Your Ref: OWPC20908
Our Ref: P/108/18/PL 12-11-2018
Please ask for:
Mr S Davis

Erection of housekeeping building within existing maintenance yard.

Church Farm Holiday Village Church Lane Pagham

Drawing Title:
Proposed Housekeeping Plan, Elevations & Section A-A
Scale:
Date: Oct 2018 1:50 & 1:100@A1
Drawn: RW
Checked By: -
4183-220-220 Proposed Housekeeping Building - Planning Draw

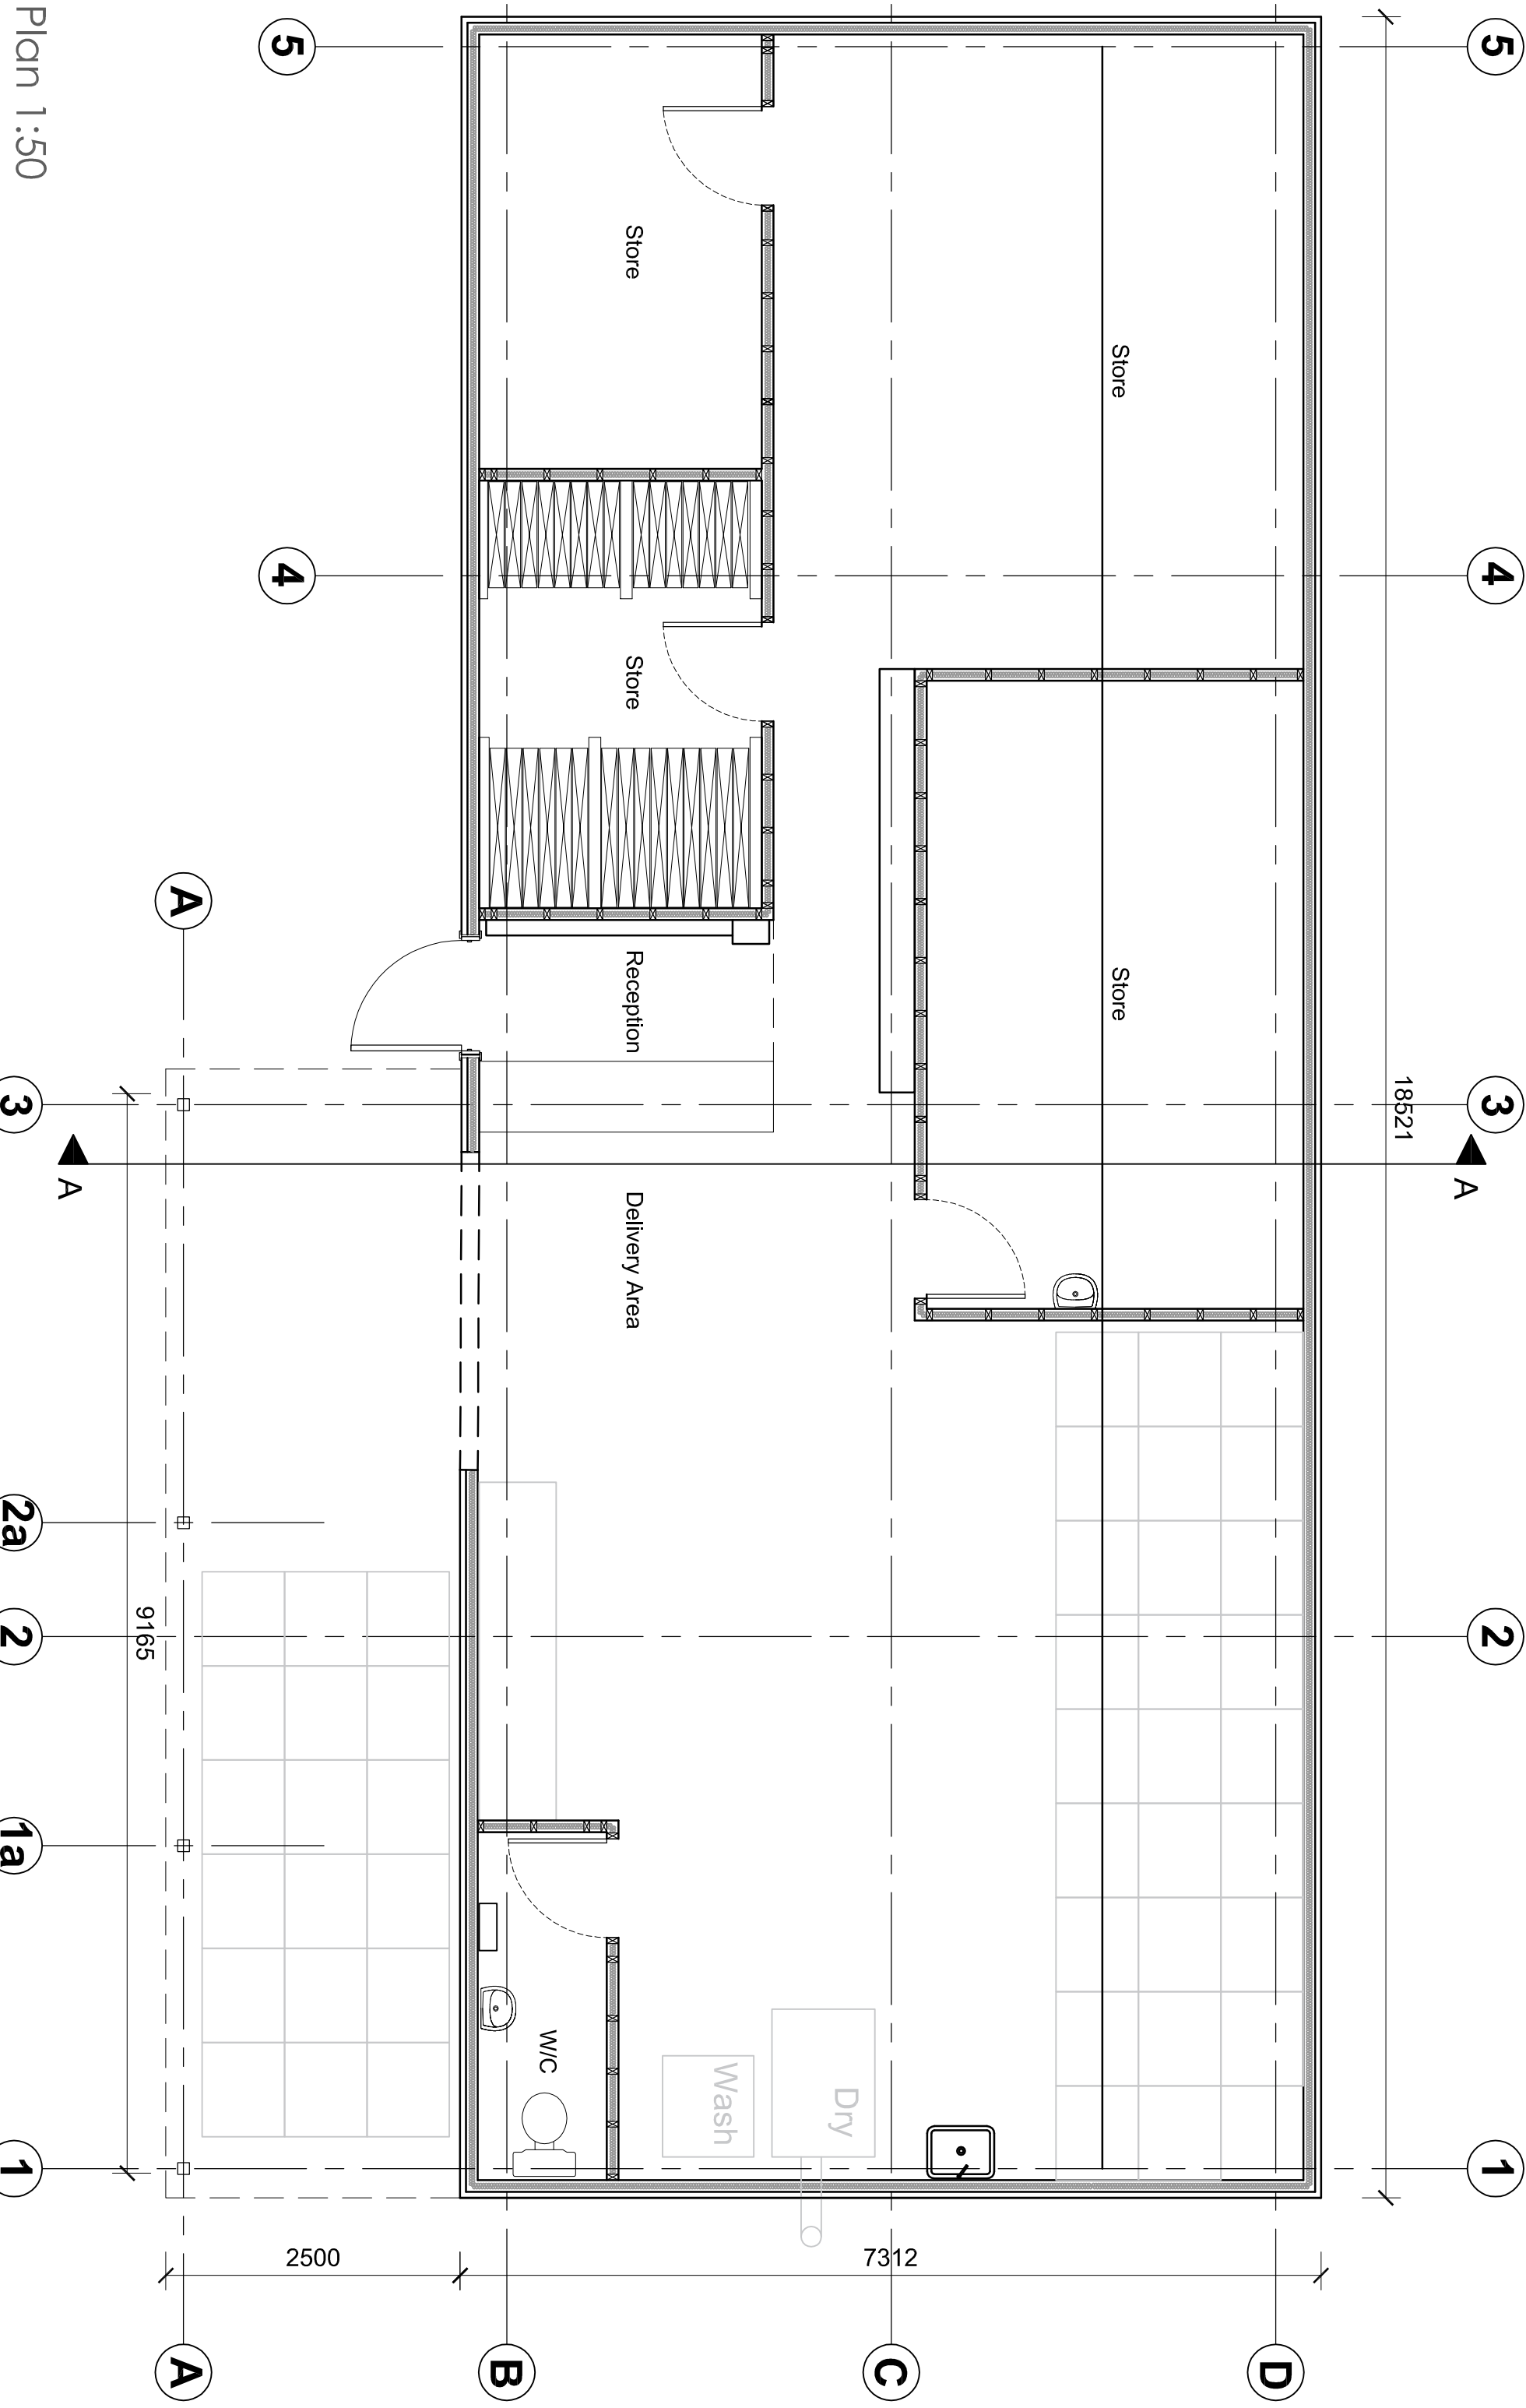
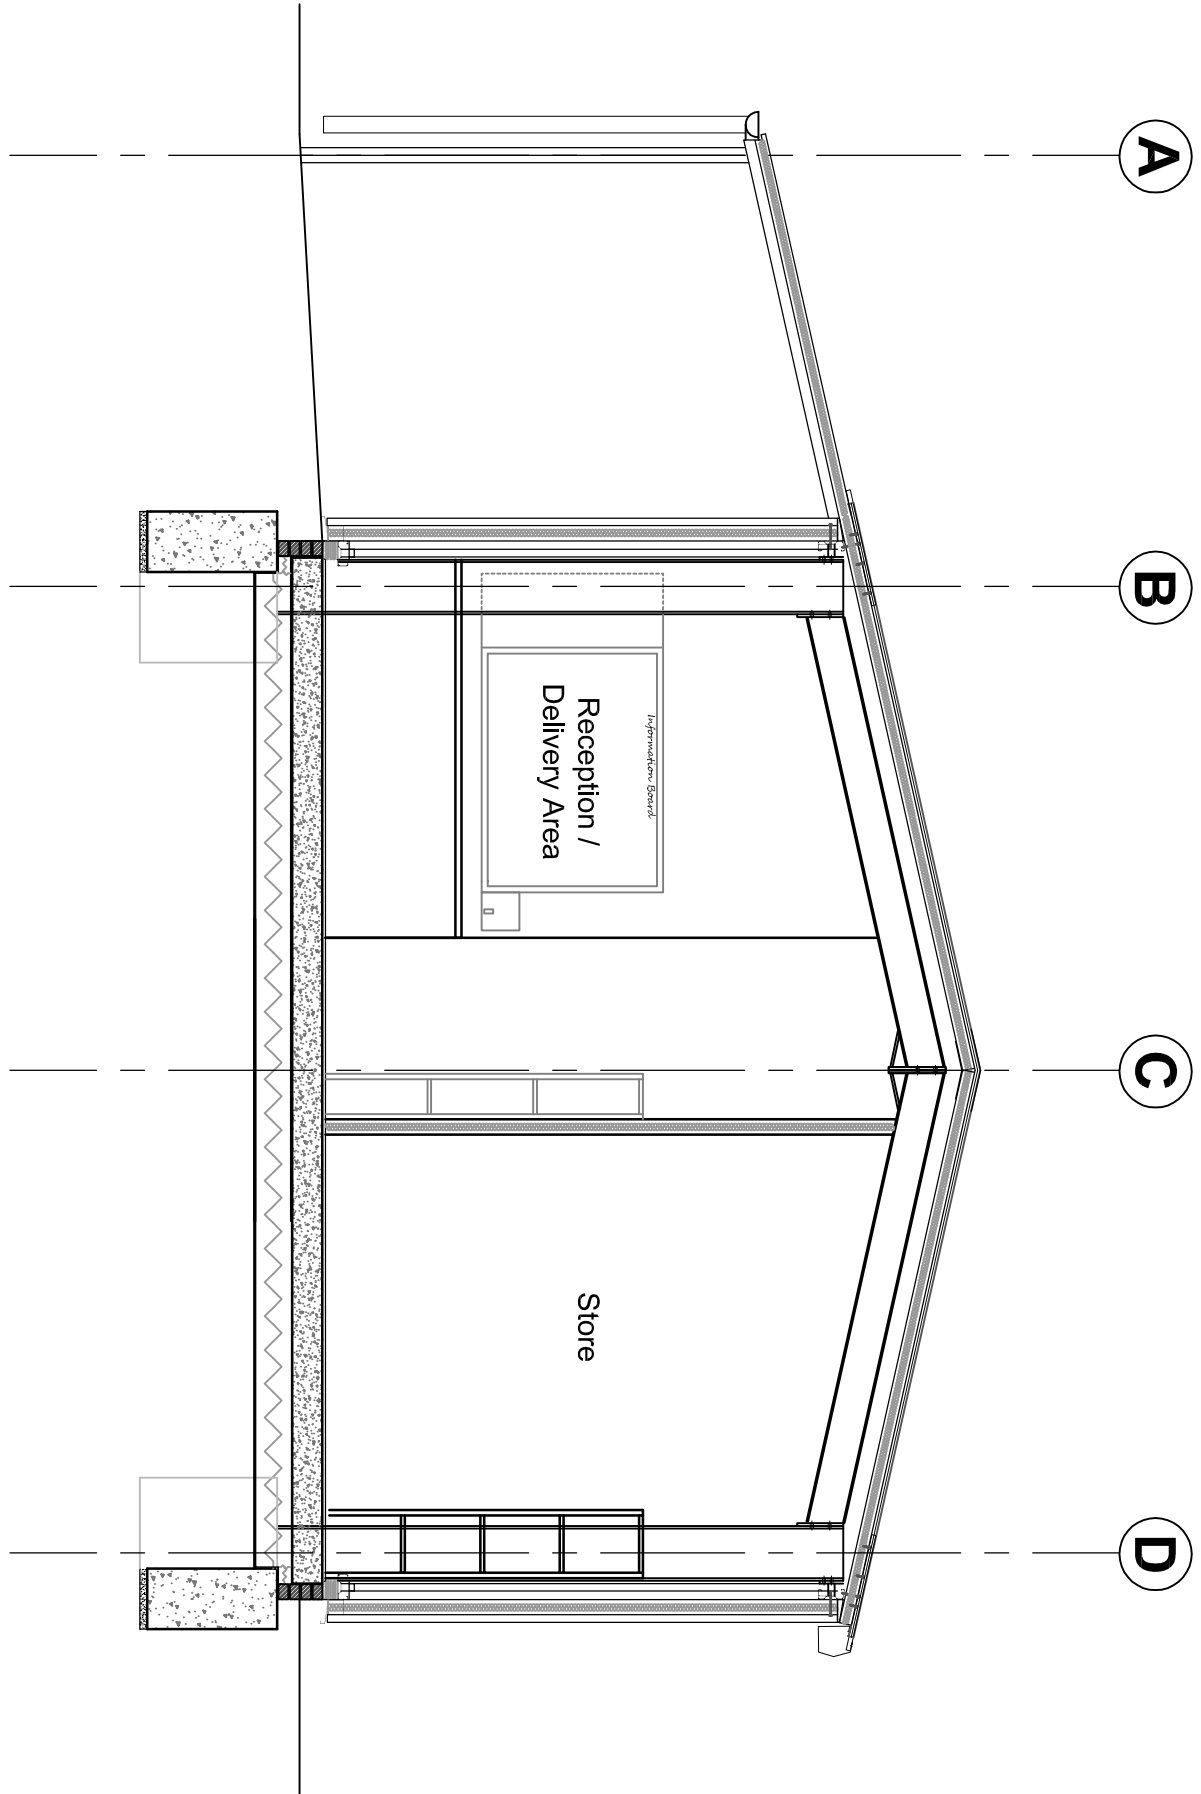
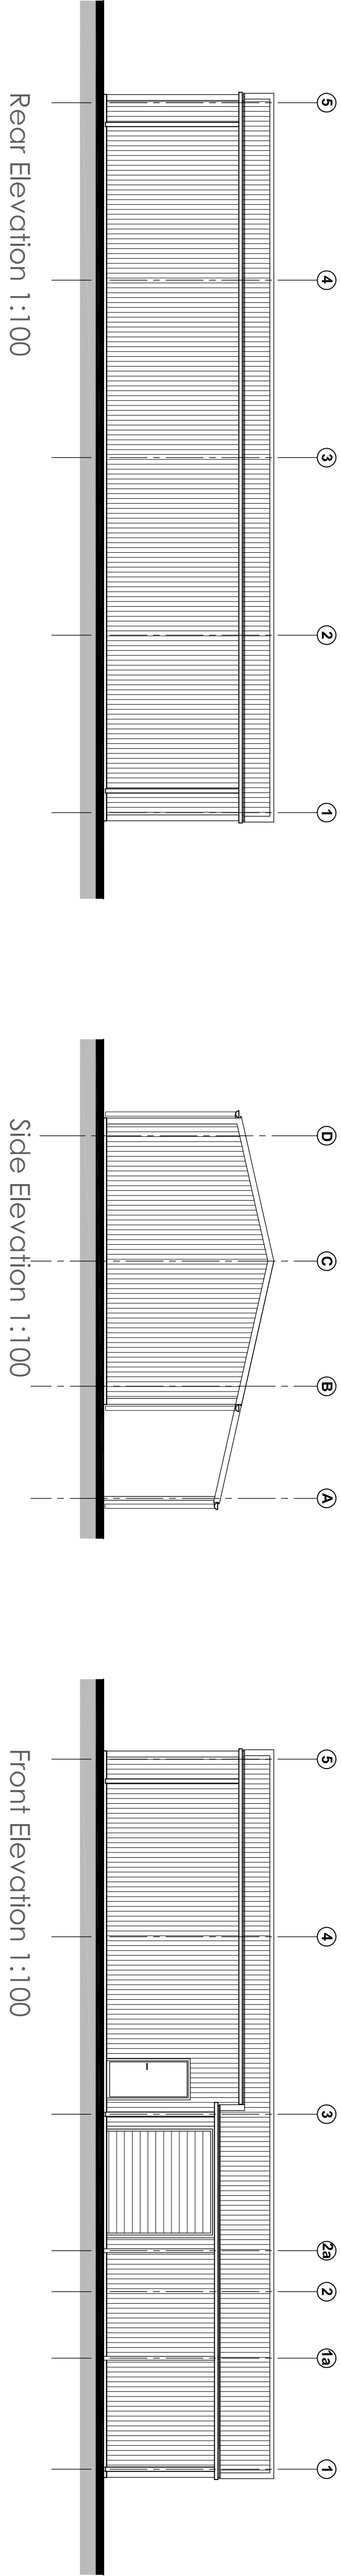
- 1) What are the proposed working hours of this building? Anything before 8am or after 6pm would be unacceptable.*
- 2) What is the proposed height (in metres) of the building as we do not require to be overshadowed by some huge warehouse.*
- 3) What plans are there to screen this building from sight, & block the noise which will happen during the opening hours?*
